# Planning Services Sign Permit Review Form

Date of Submittal	Application Number	Applicant	Landowner
9/13/2021	SIGN2109-0001	Jim Moore	New Town Property Holdings LLC

Contact Person	Contact Number	Sign Location	PIN Number
Jim Moore	910-922-7010	78 Piney Grove Rawls Rd.	0655-41-3933.000

Aluminum Ground Sign

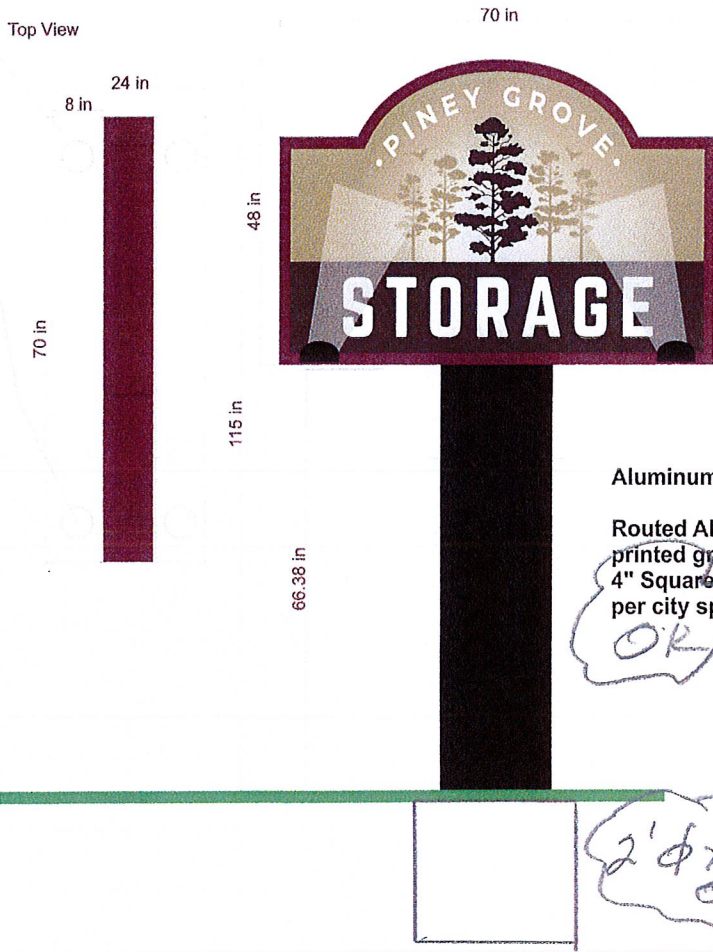
Comments	<p>1. Please provide the setbacks from the proposed sign to the property lines and the RW on the site plan.</p> <p>2. Supporting poles must be a minimum 1/4 of the sign face and encased in ornamental shell of stone, brick, ornamental metal, or similar materials. Please widen the poles accordingly, or design a different support method for the sign. Please contact me with questions.</p>
----------	---
